DRB CASE ACTION LOG

Complete
10-26-10
YS
SITE PLAN FOR BUILDING PERMIT

DRB Application No.: 10DRB-70222 Project # 1008327
Project Name: Unplatted Land Of St. Jude Thaddeus Parish
Agent: MULLEN HELLER ARCHITECTURE Phone No.: _____

SUBJECT: Project # 1008327

PLANT LEGEND

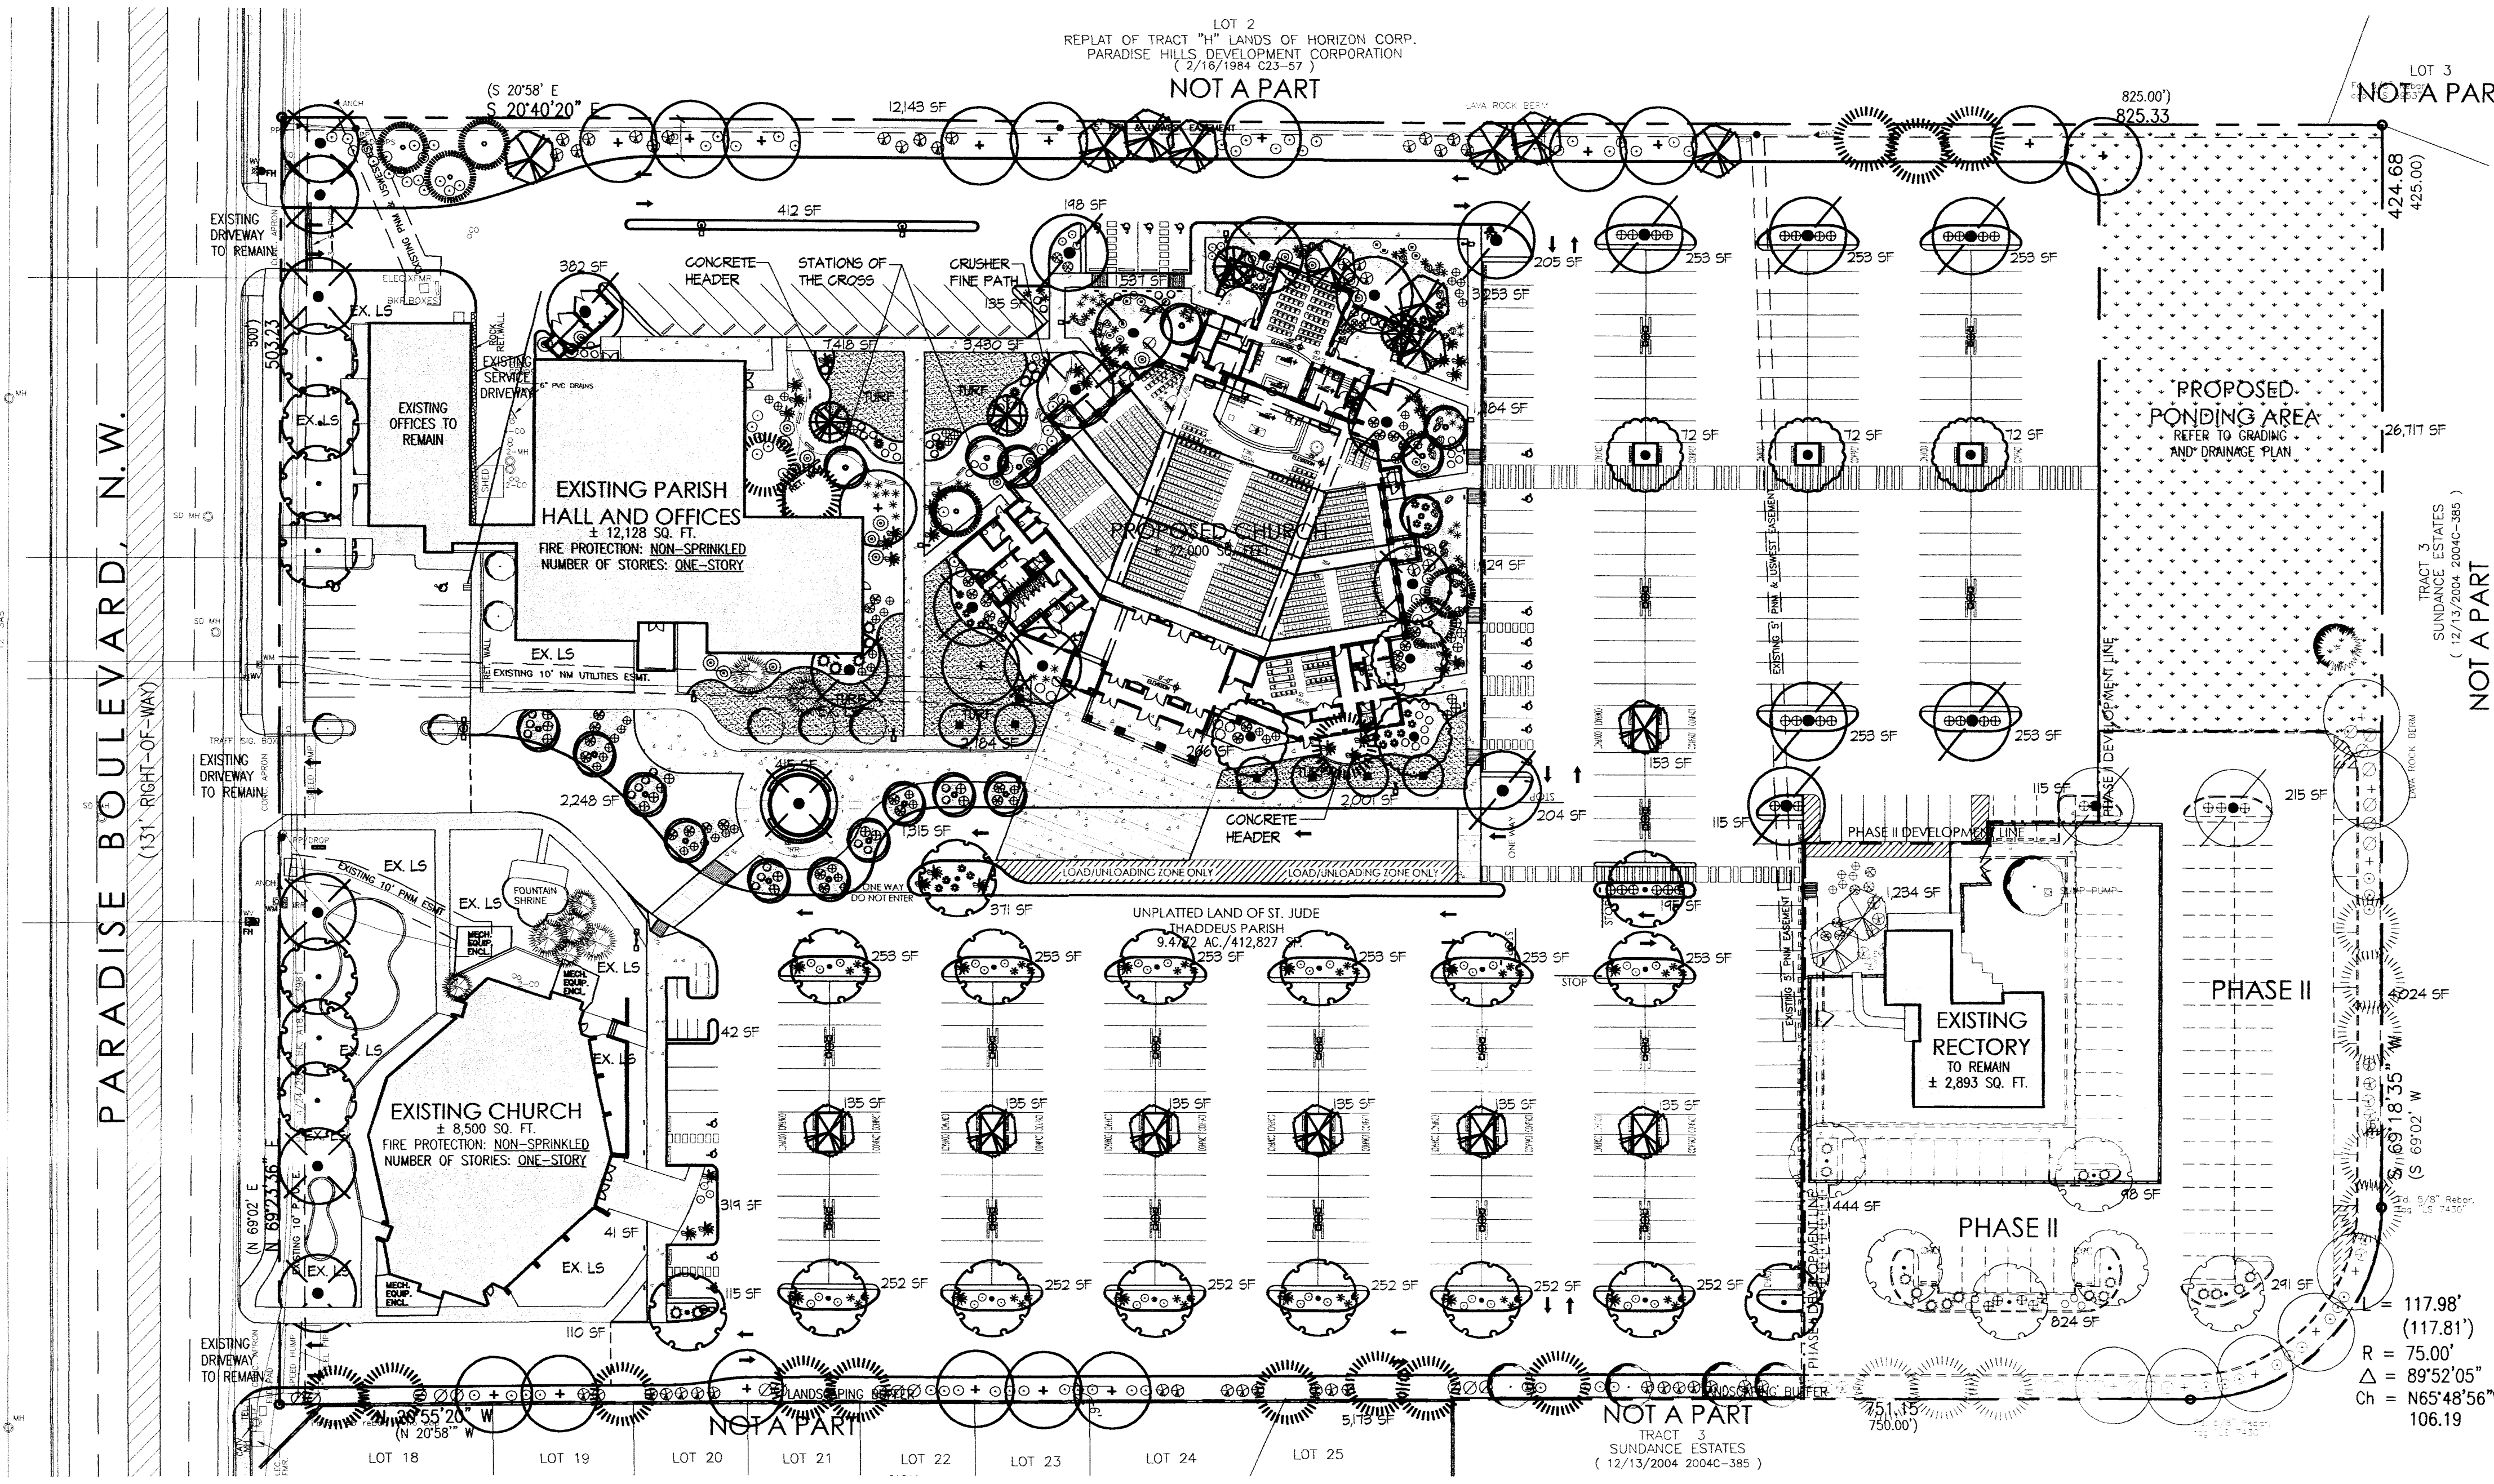
The requirement for a landscape buffer of at least 10' wide and spacing of trees equal to 75% of the mature canopy is not fully complied with on west side of the

church property that abuts the residential zone. The width of the buffer on the northwest portion of the site is 7' for approximately 160', while only 90' is allowed per the condition. The spacing of trees on the west side is not equal to 75% of the mature canopy diameter of the trees. The landscaping on the west side of the church property that abuts the residential zone shows 14 trees that have a spread between 25' and 30'. 21 trees are required to meet the 75% requirement on the western side of the church property. The landscape buffer on the east side of the church property that abuts the residential zone is also not equal to 75% of the mature canopy diameter of the trees. The landscaping on the east side shows 24 trees that have a spread between 25' and 30'. 33 trees are required on the eastern side of the church property that abuts the residential zone.

The total amount of street trees shown along Paradise Boulevard is still 13. Two more street trees are required.

The applicant has not shown the quantity, scientific/common name, the installed size and mature size (height & spread), and water use of all existing plants. The applicant simply states that for more detailed information reference the landscape plan associated with the original site development. Zoning Enforcement has stated that the details of all existing plants must be shown.

Pedestrian walkways have not been lined with adjacent street trees approximately 25 feet on center. The current landscape plan does not meet this requirement. Applicant will have to either add more shade trees to line the pedestrian walkways or move the existing trees closer to the pedestrian walkways.

project title
St. Jude Thaddeus Catholic Church
 5712 Paradise Blvd NW
 Albuquerque, New Mexico 87114
 sheet title
Exterior Elevations

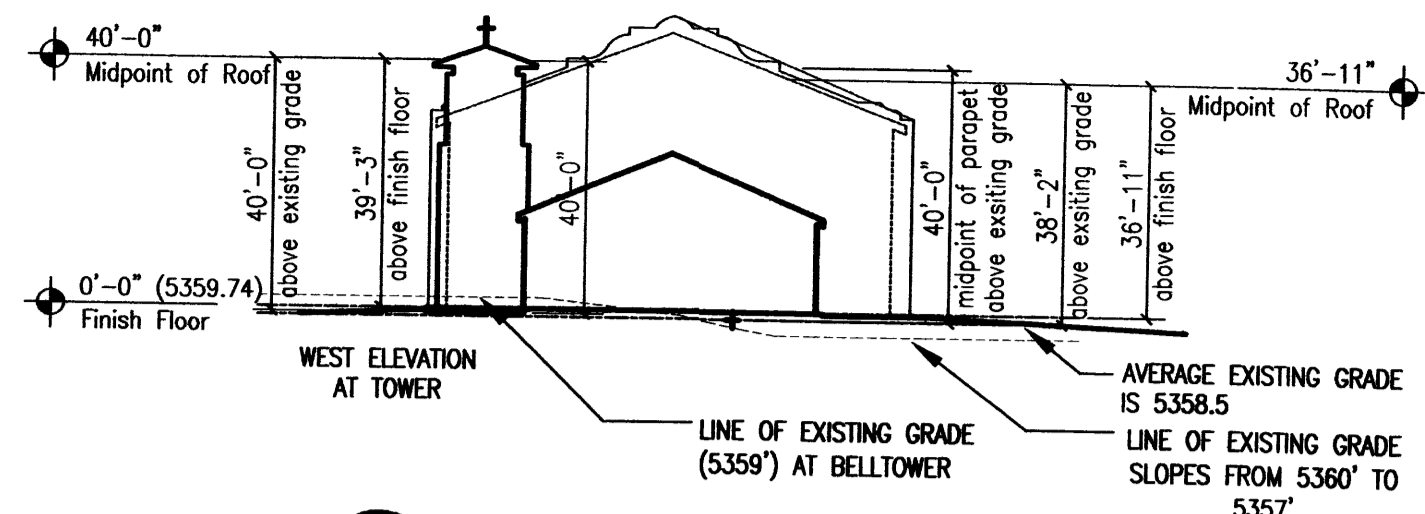
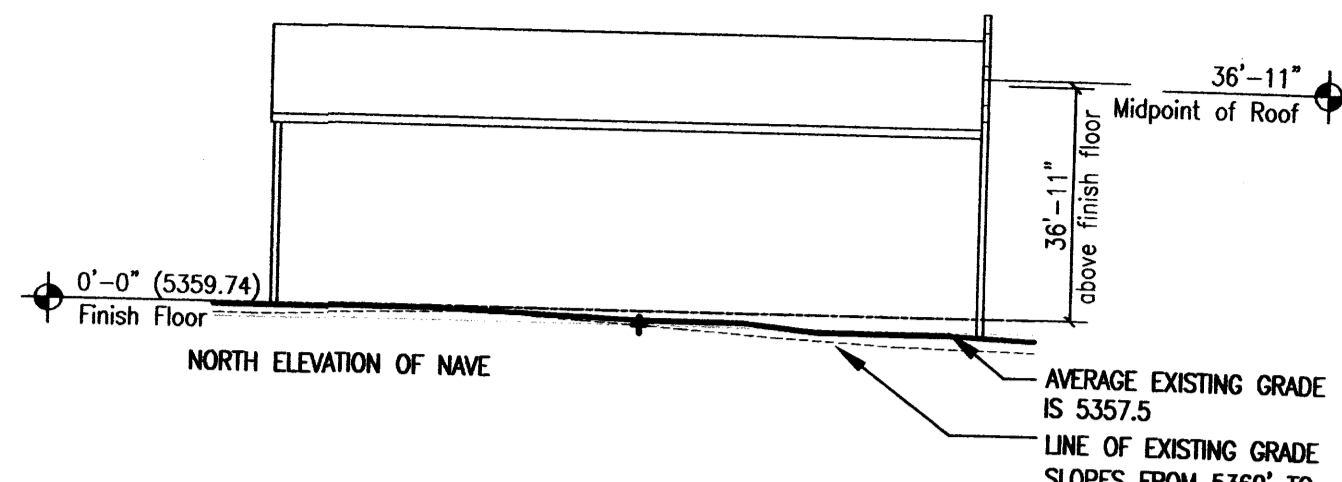
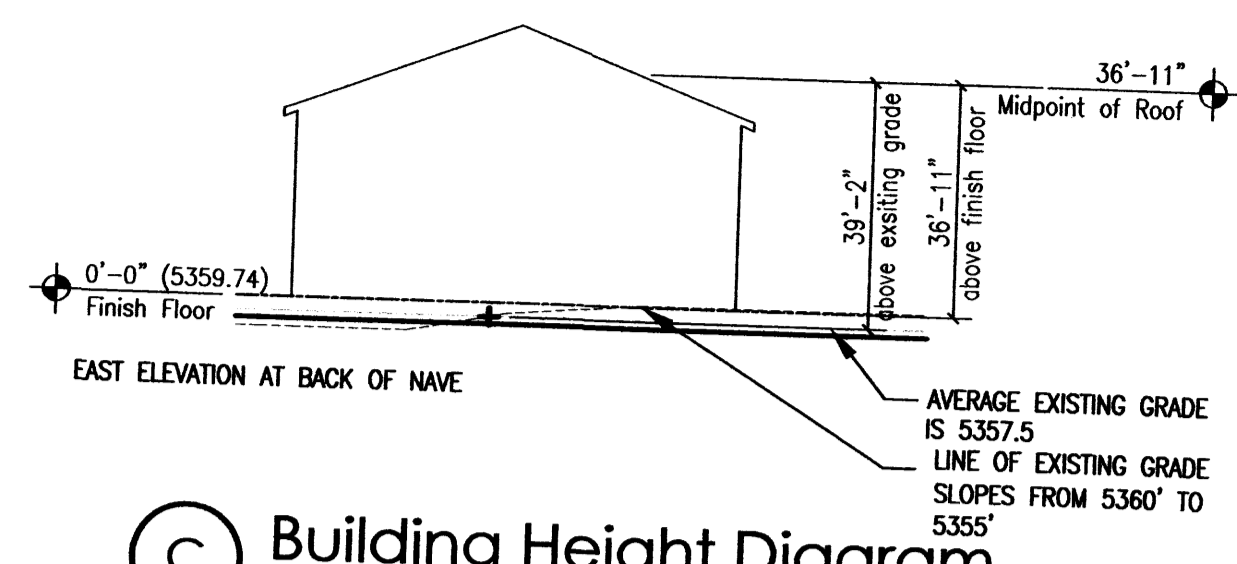
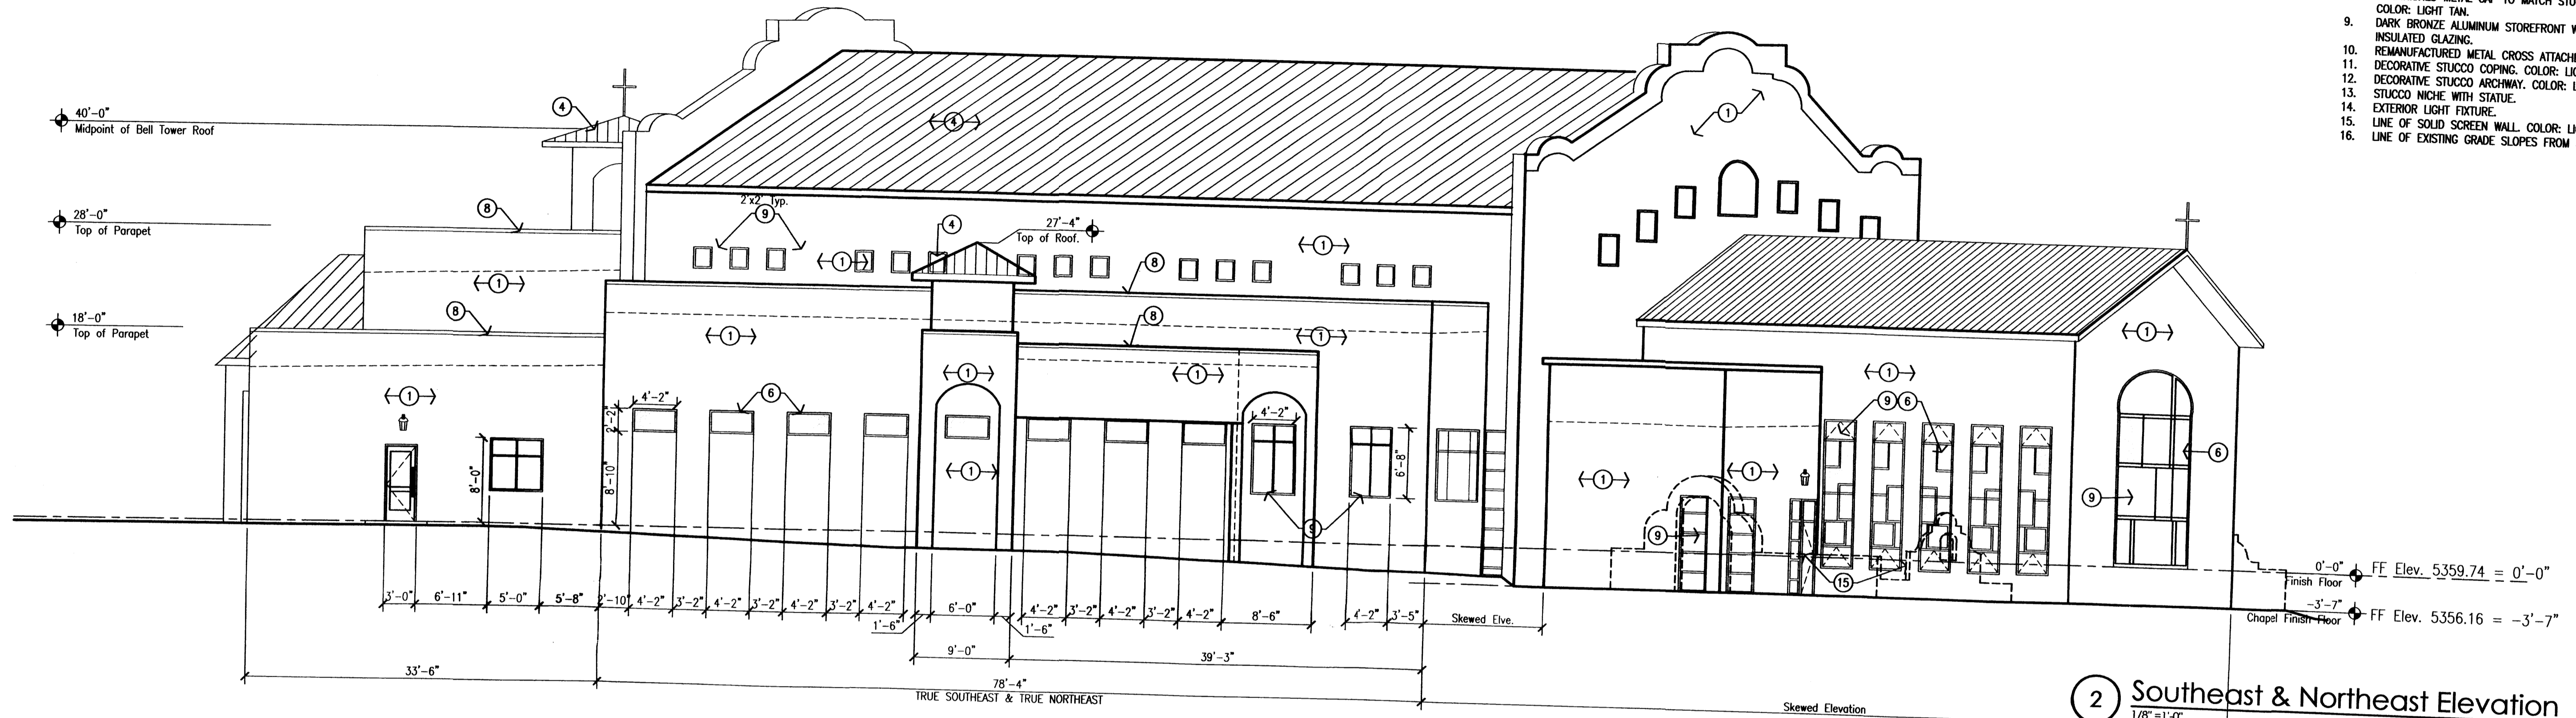
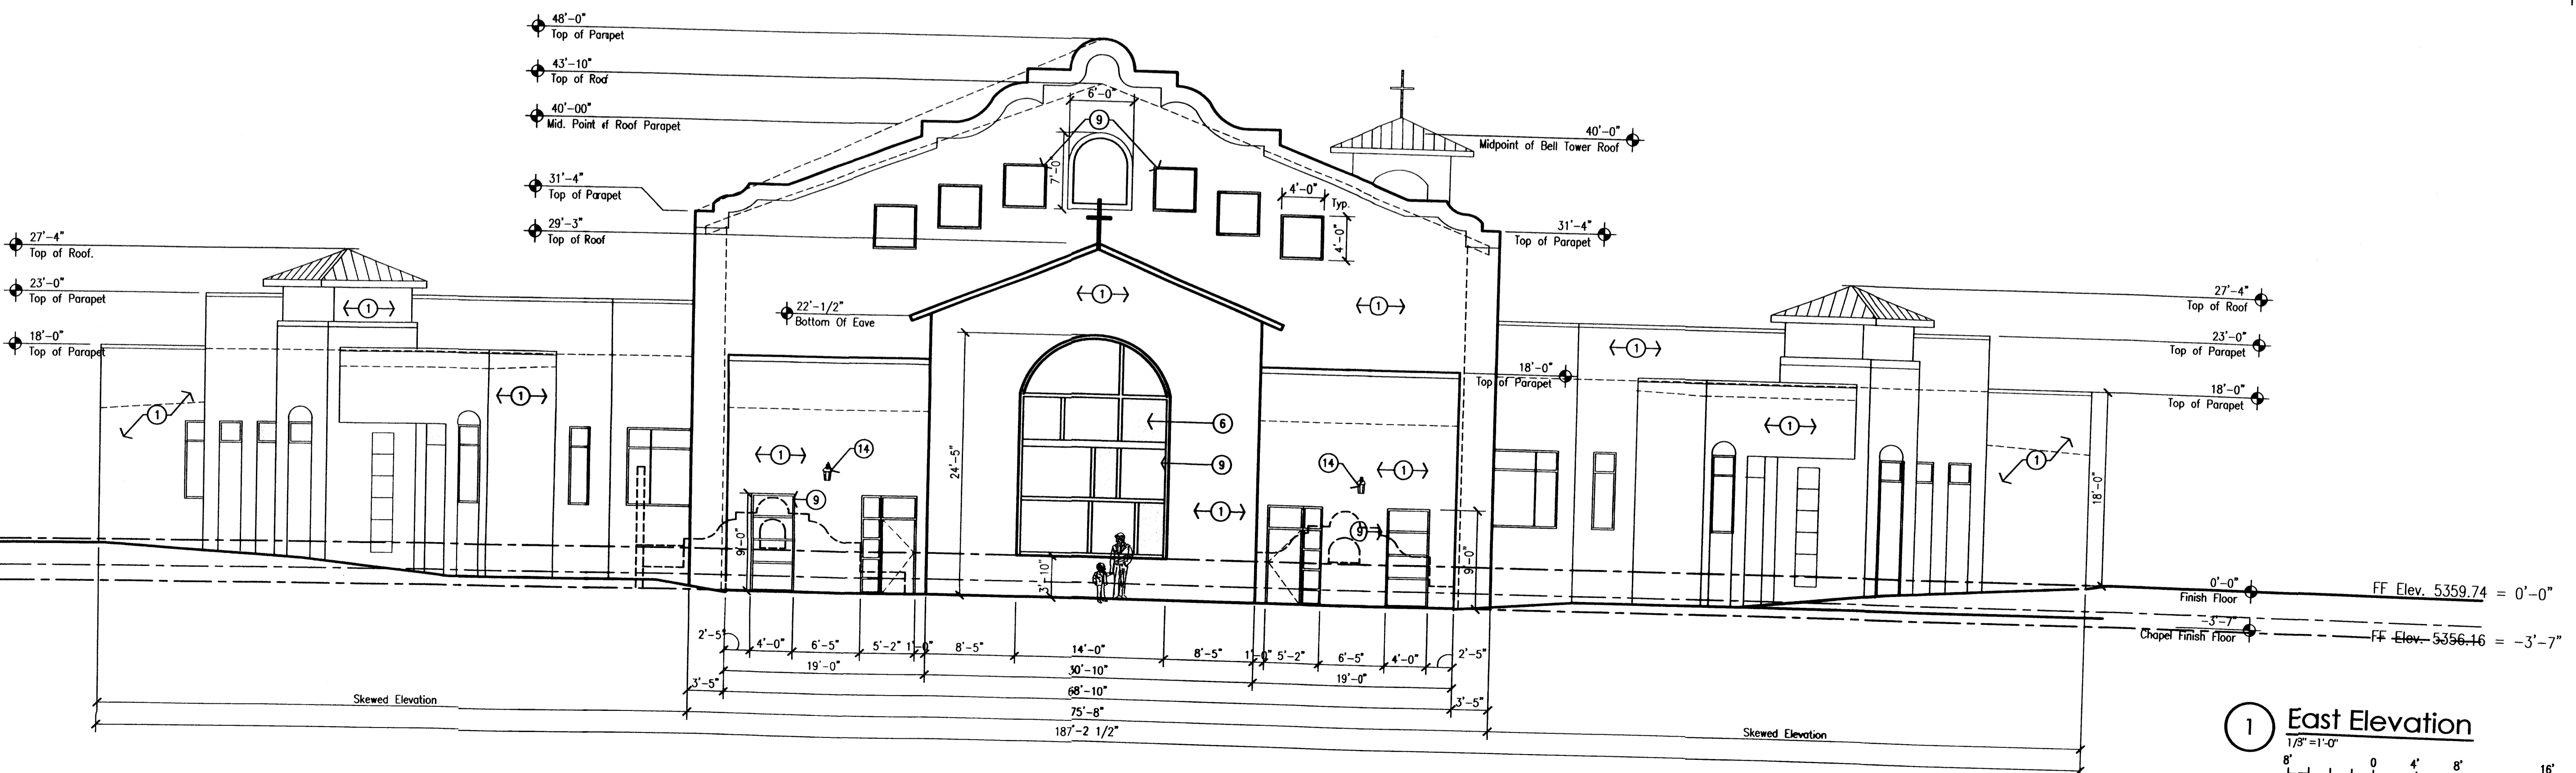
The exterior elevations sheet 5 of 7 shows the midpoint of the bell tower roof to be 40', which would comply with the condition. However, the church building height is shown as 48' at the top of the parapet and 43'10" at the top of the roof. Zoning Enforcement considers the 48' tall parapet to be a wall and not a roof, which is in violation of the North West Mesa Escarpment Plan (NWMEP). As a result of Zoning Enforcement considering the parapet as a wall and not a roof, the structure cannot be measured as a roof (if the structure were considered a roof then it would be measured to the average height between the plate and the ridge of a gable, hip, or gambrel roof, per the definition of Height in Section 14-16-1-5 of the Zoning Code). The applicant has stated that they will most likely seek a variance from the Zoning Hearing Examiner.
